# MONUMENT WATERLINE & STORAGE TANK

## CONSTRUCTION PLANS MONUMENT, CO

FA PROJECT NO. 04-20-0153  
JANUARY, 2022

PROJECT NO: 04-20-0153	
SHEET NO: 3	
DATE: JUNE, 2021	PAGE NO: 3 OF 19

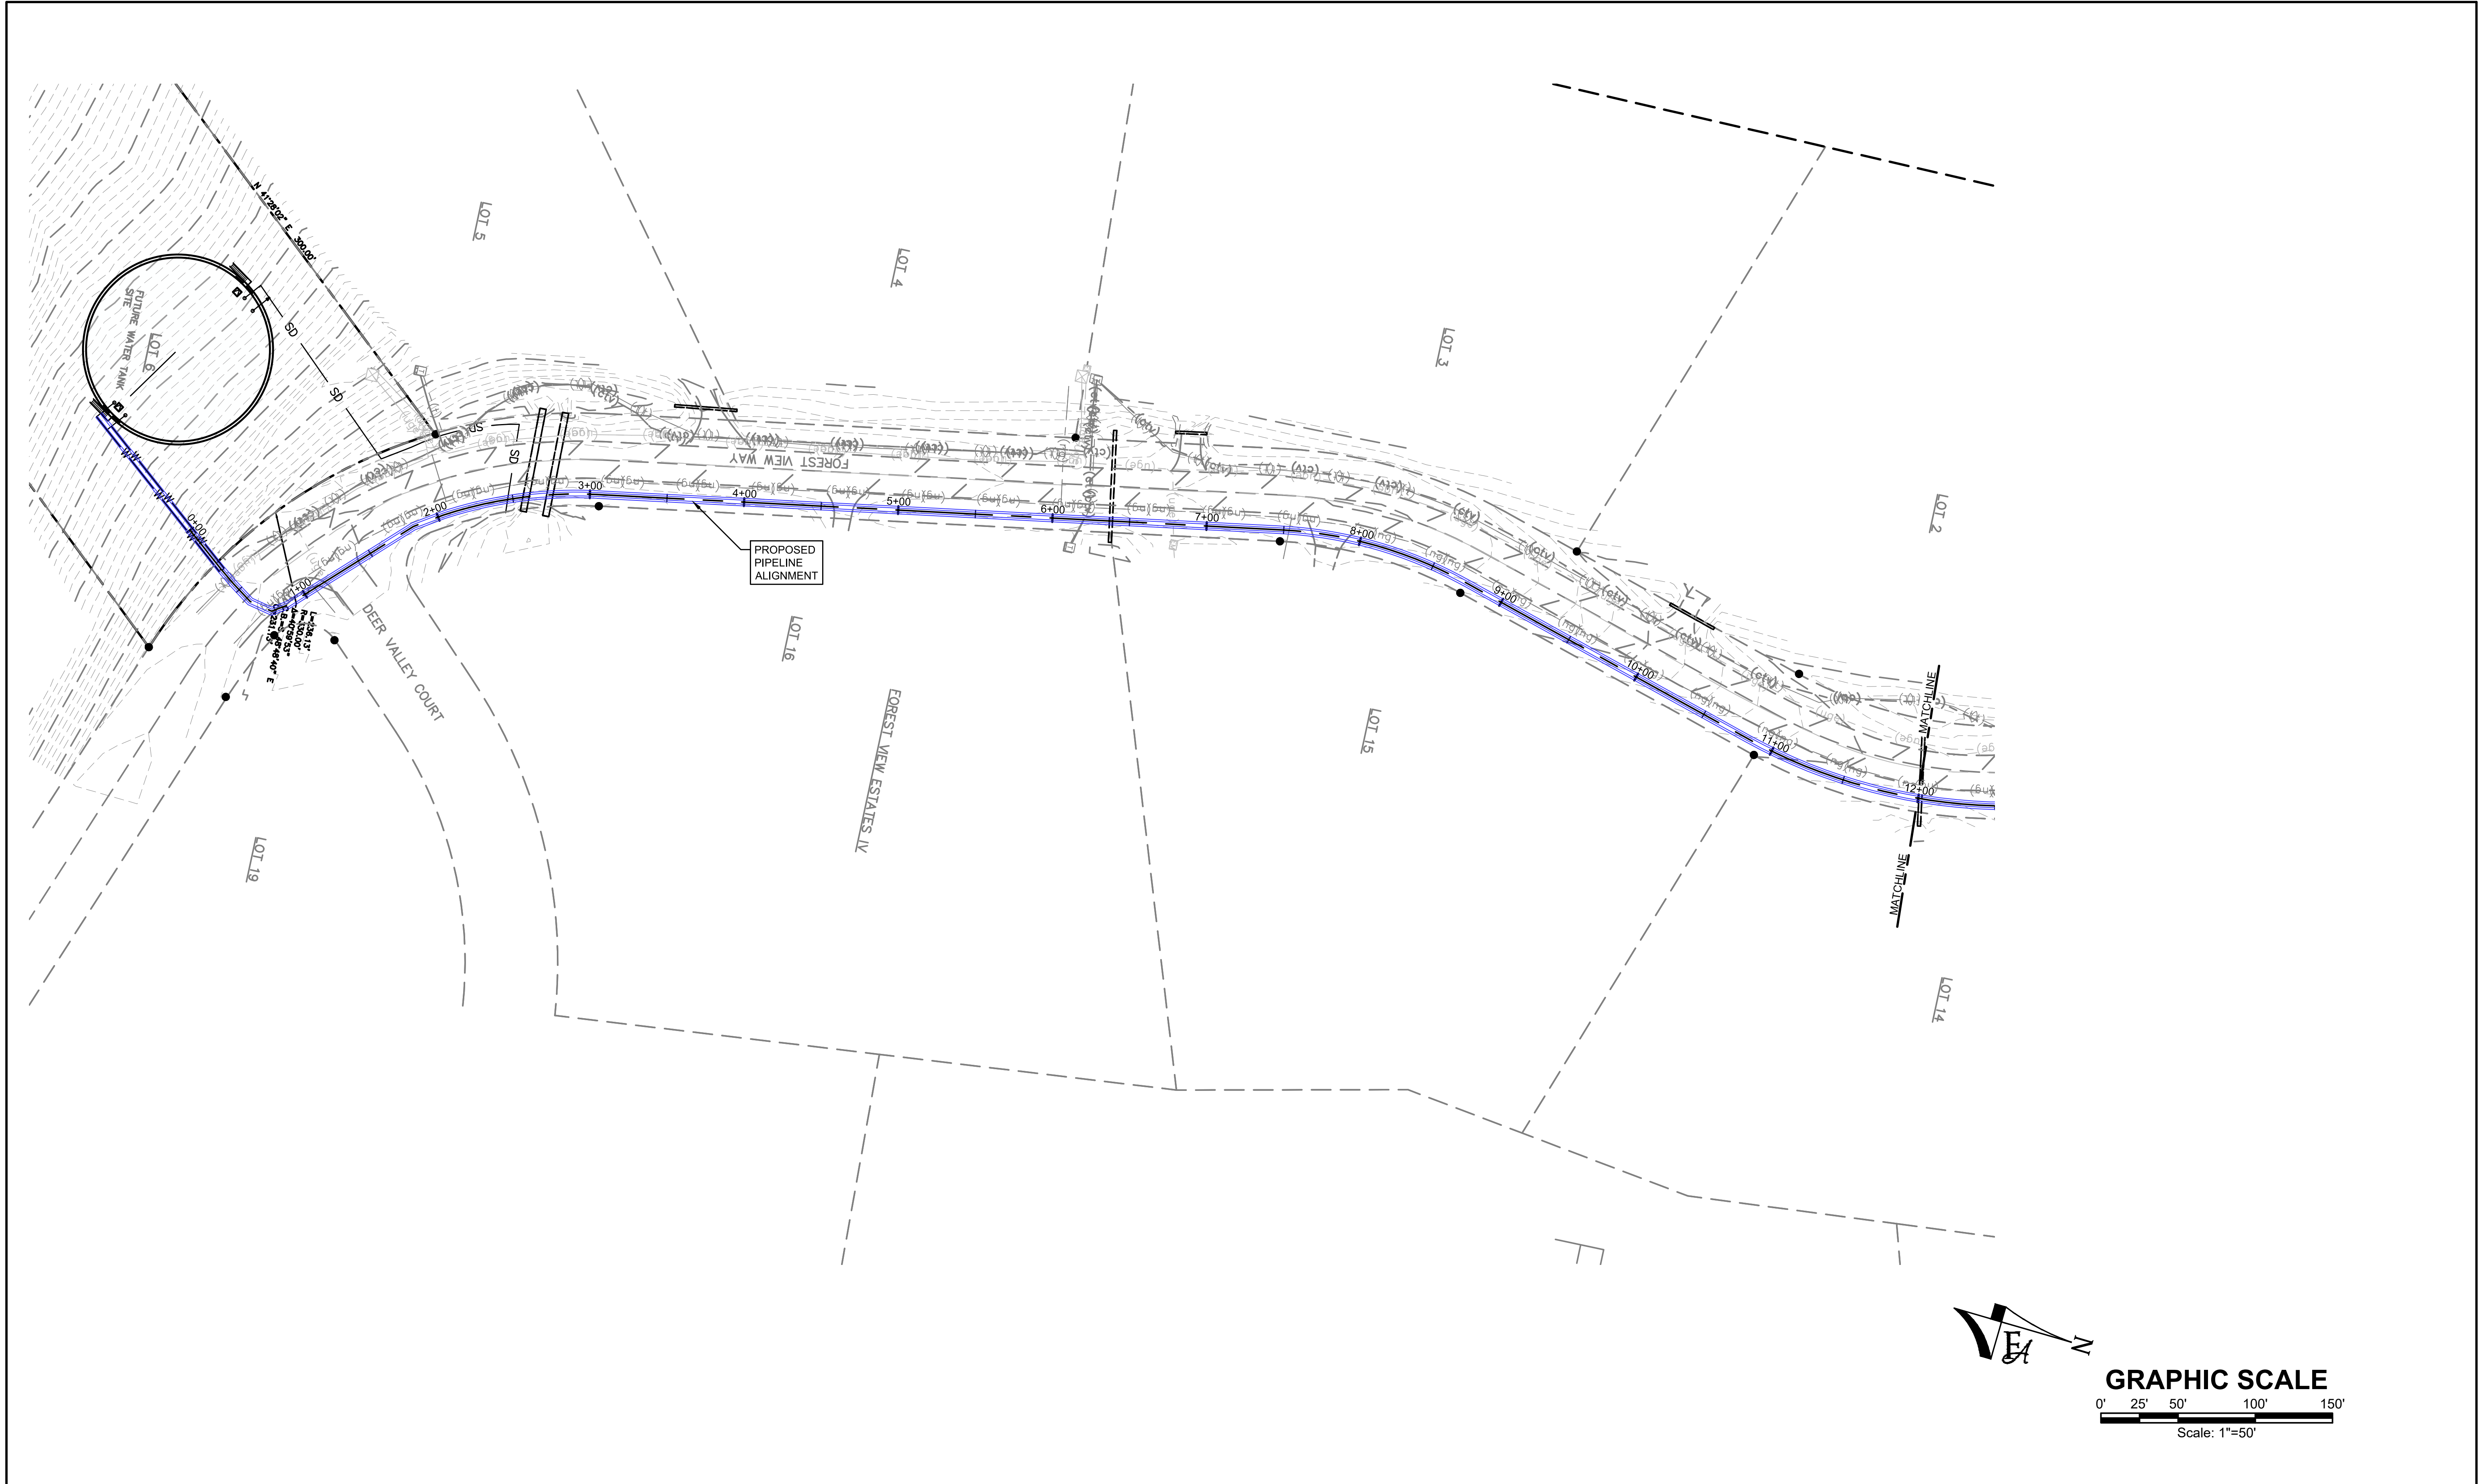
Please make sure the asphalt linestyle is shown on the plan sheet since it appears it is not.
